SUBJECT: **Permit Modification Request for TIP No. R-2906C**, Wake County,
Federal Aid No. HPSTP-55(12), State Project No. 8.1403901, \$200 Debit
WBS Element 34514.1.1

The North Carolina Department of Transportation (NCDOT) proposes to modify the construction plans for the abovementioned project. NCDOT proposes to construct a temporary diversion channel to the north of Martin Luther King Boulevard.

The purpose of this letter is to request modifications to the CWA Section 404 Permit issued by the USACE and the 401 Water Quality Certification issued by the NC Division of Water Quality. This change addresses temporary diversion channel construction. Revised construction plans (Sheet 22) are attached.

R-2906C, permit drawing sheets 45 and 46 of 52, Sites AF, AH, AI, and AJ, Station Y47
17+65 to 22+19 left

### TEMPORARY DIVERSION DETAIL

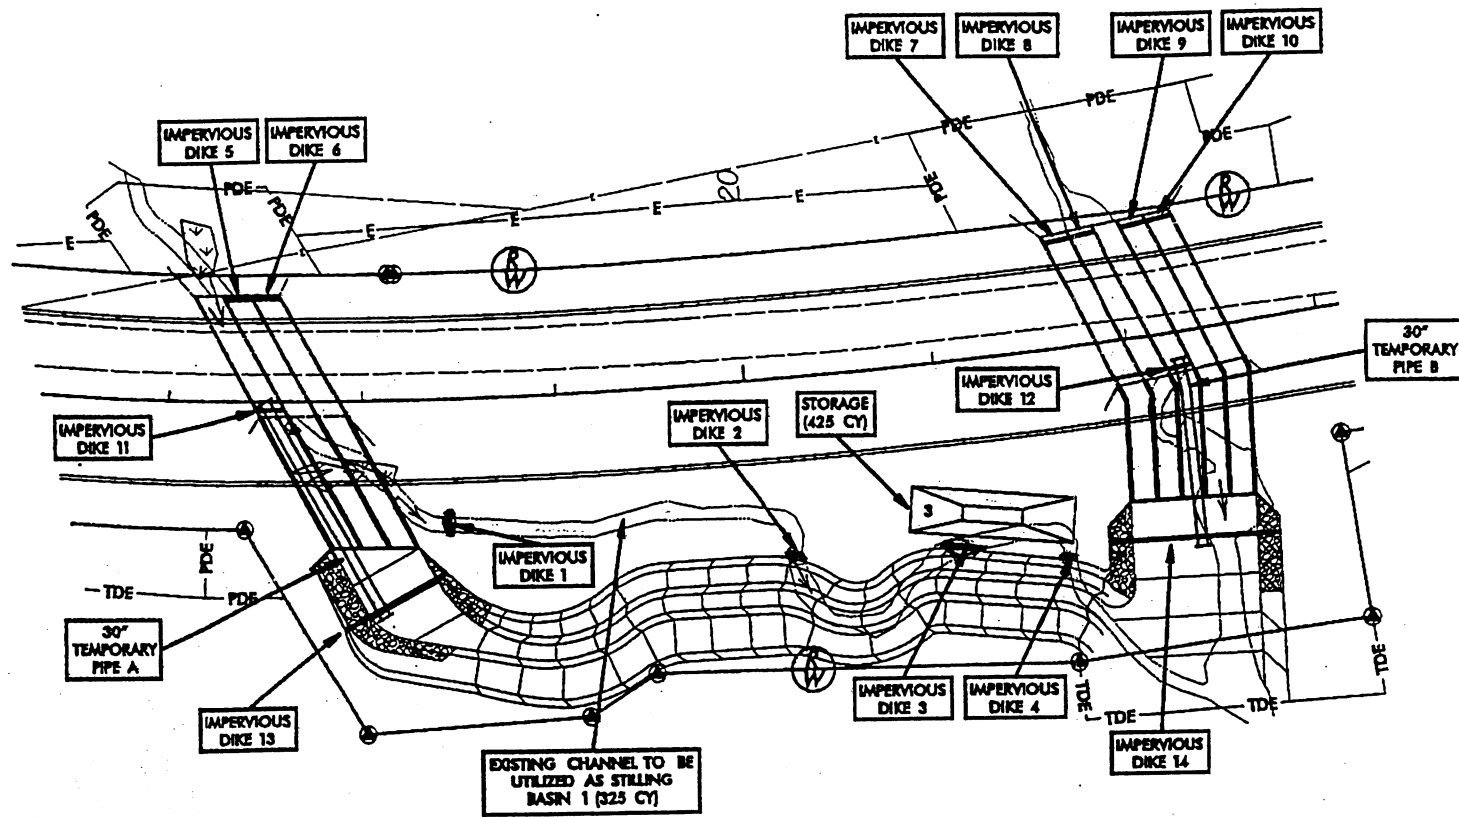
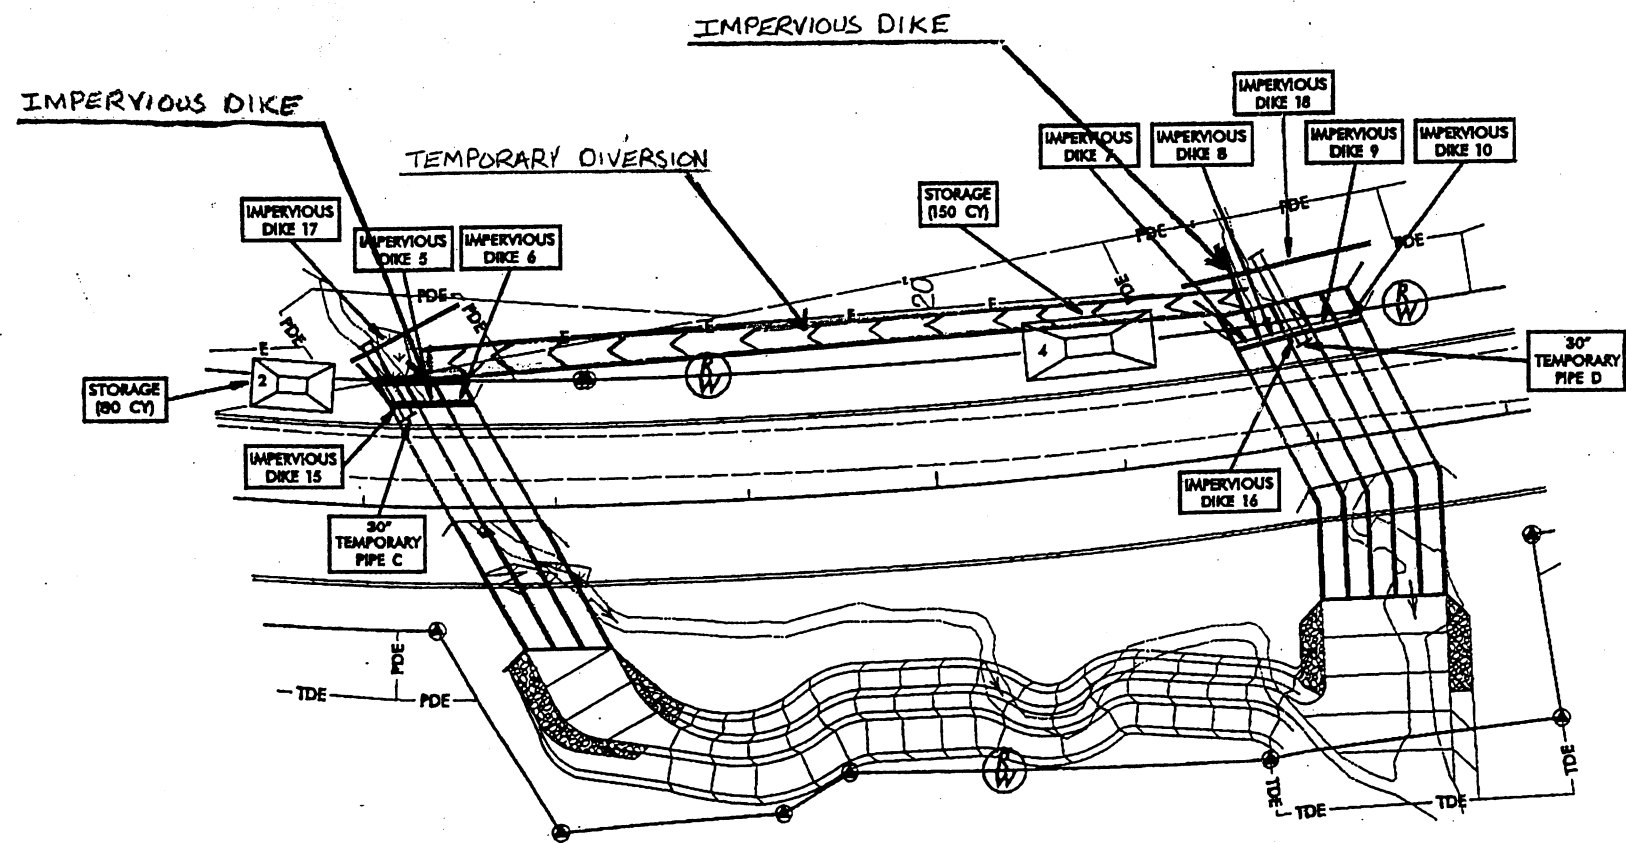
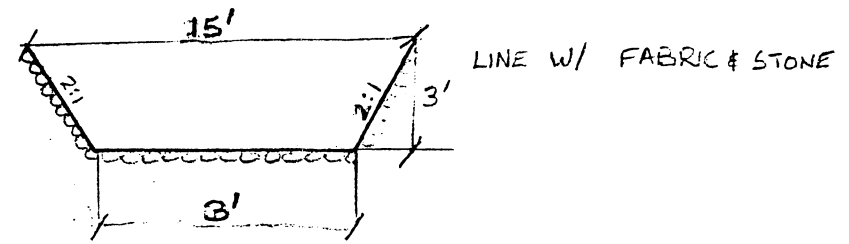
The construction of this temporary channel will allow for the proposed channel relocation (approximate station 17+65 to 22+19 right of Y47) as well as the proposed culvert extensions (approximate station 17+65 right and left of Y47) to be constructed while in the dry. The diversion will be lined with fabric and rock and the far side of the creek at the outlet end will be stabilized with rock or coir fiber. A stilling basin on the left side of the road will be used to pump around while the culverts are extended. The diversion channel will be in use for approximately 5 months.

The dimensions of the proposed temporary channel are as follows:

| Length: | 440 ft |
| Top of channel width: | 15 ft |
| Bottom of channel width: | 3 ft |
| Side slopes: | 2:1 |

The area disturbed will be approximately 733 yd². The total excavation will be approximately 440 yd³. The amount of fabric that will line the temporary channel will be approximately 803 yd². Approximately 0.01 ac of wetlands will be impacted as a result of this action.
